CROSSROADS MIXED USE FILING NO. 2

CONSTRUCTION PLANS

EL PASO COUNTY FILE NO. SF2238

PEDESTRIAN RAMP DETAILS

**CENTRAL RAIL POINT &
EX SOUTHERN RAIL POINT**

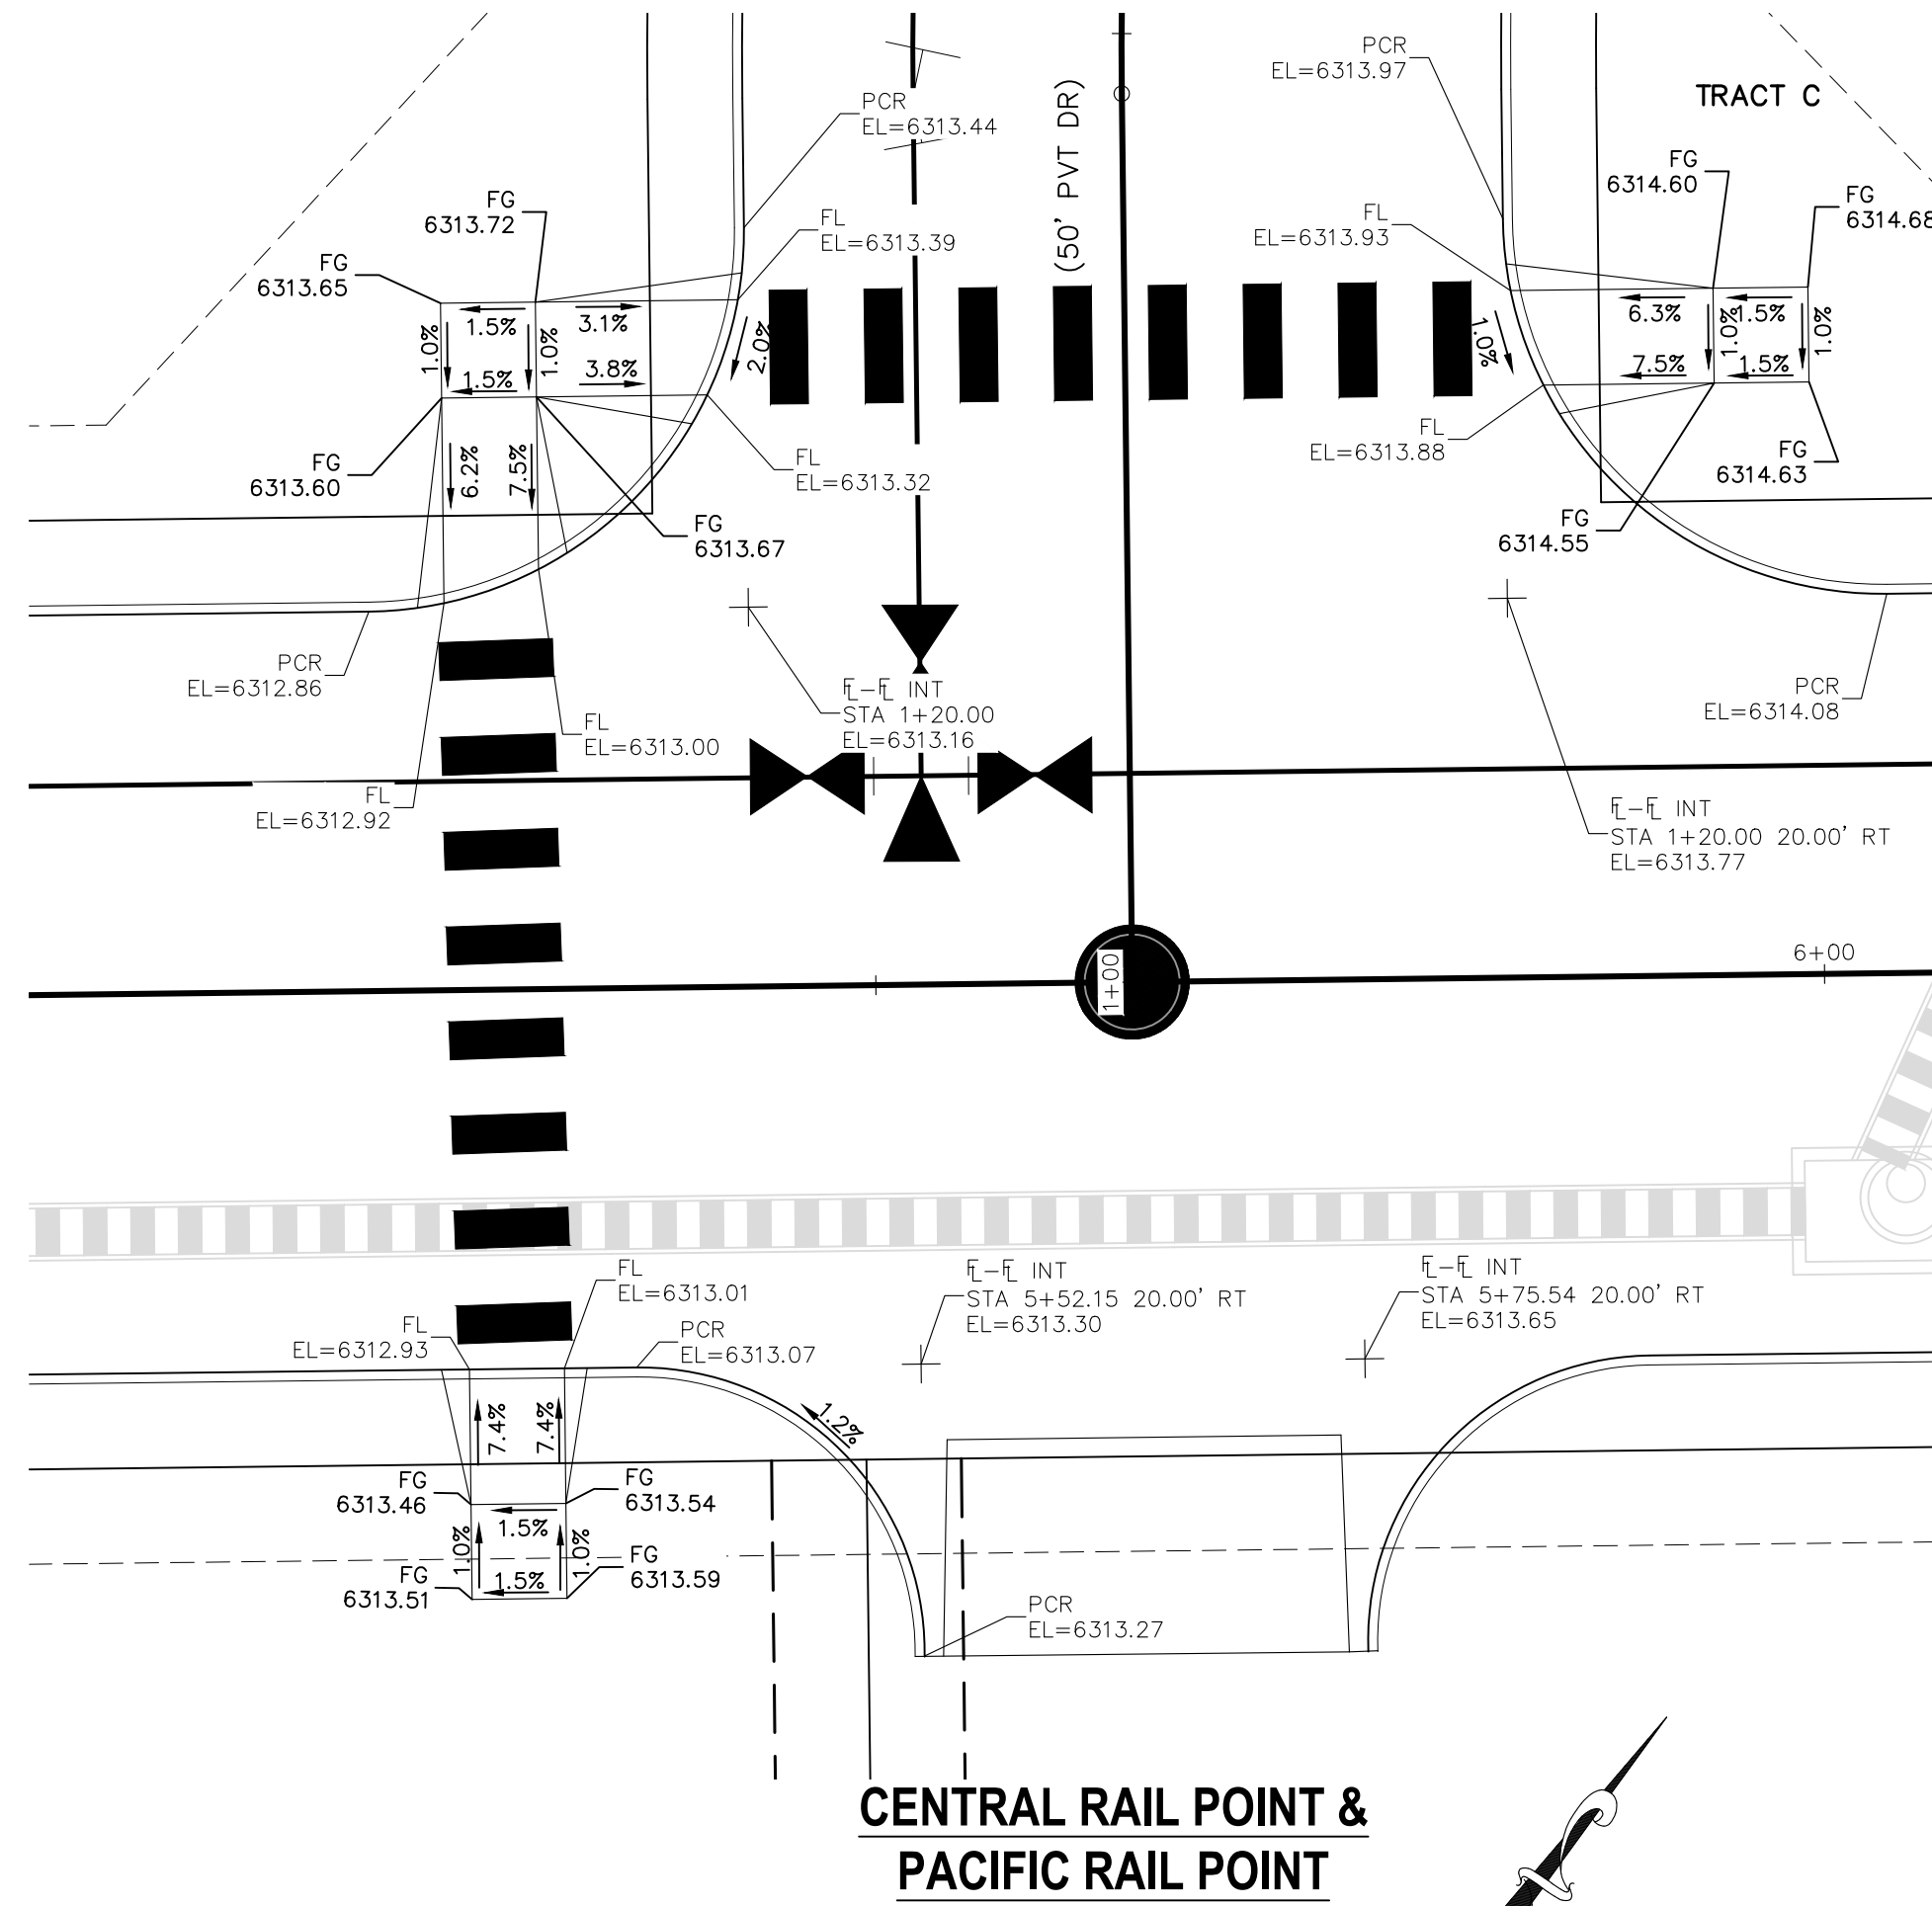
provide truncated
dome

Identify on the plan
where this is located.

THE TRUNCATED DOME
HAS BEEN ADDED.

THE LOCATION OF THE
PEDESTRIAN RAMP HAS
BEEN ADDED TO THE
DRAWING DESCRIPTION.
